# CITY OF ALBUQUERQUE

December 19, 2019

RE: Barlow Shop 6205 Wilshire NE Grading and Drainage Plan Engineer's Stamp Date: 12/4/19 Hydrology File: C18D070

GRADING AND DRAINAGE PLAN

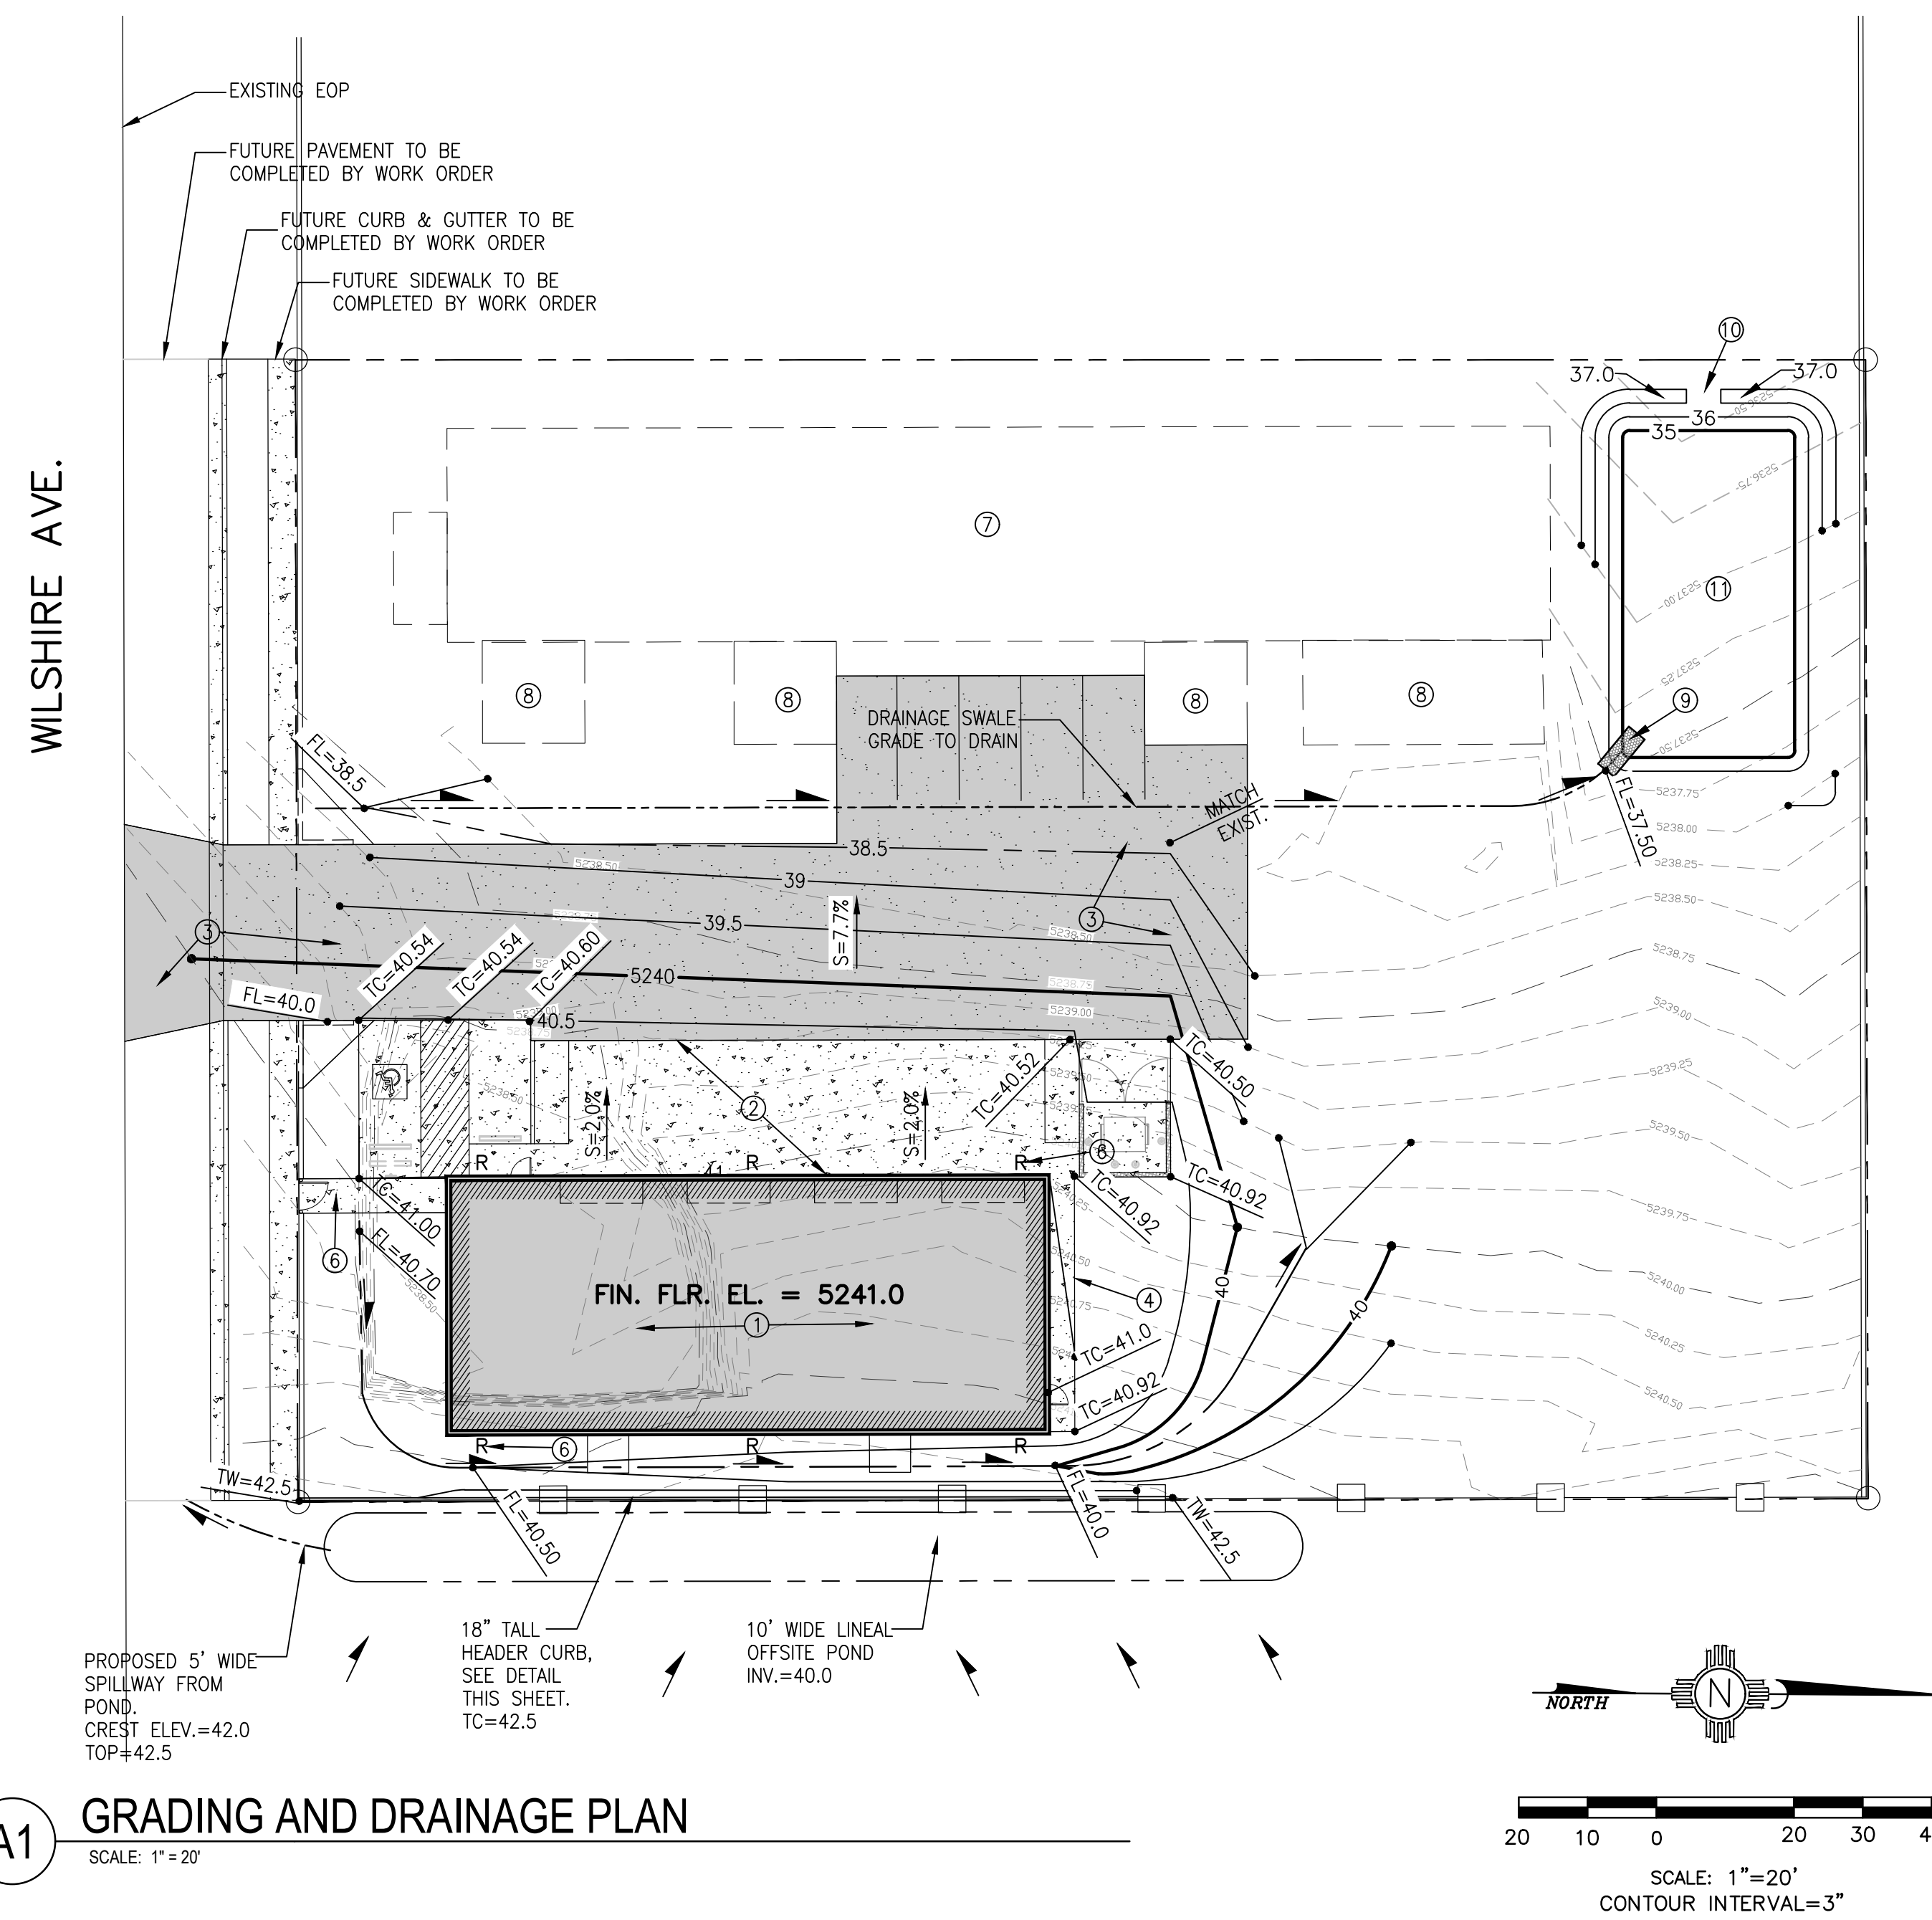
- This project requires major infrastructure (construction of Wilshire half-street), so a DRB approved Site Plan, with infrastructure list is required prior to considering this site for Building Permit.

- NM 87103
   As part of the DRB Site Plan, an approved Conceptual Grading and Drainage Plan is required; show all improvements in the ROW; these should be labeled as "to be constructed by Work Order, or similar.

- Www.cabq.gov
   3. This project must demonstrate compliance with the North Albuquerque Acres Master Drainage Plan (RTI, 1998); storm drain may be required.

- 4. Show all existing and proposed property lines.
  - 5. Provide written and signed permission from the owner to the east for the grading and pond construction on their property.

- 6. North arrow is oriented wrong.
  - 7. The plan should be labeled "Conceptual not for Construction" or similar, for inclusion in the Site Plan.
  - 8. Hydraulic calculations need to be provided for all proposed drainage facilities.
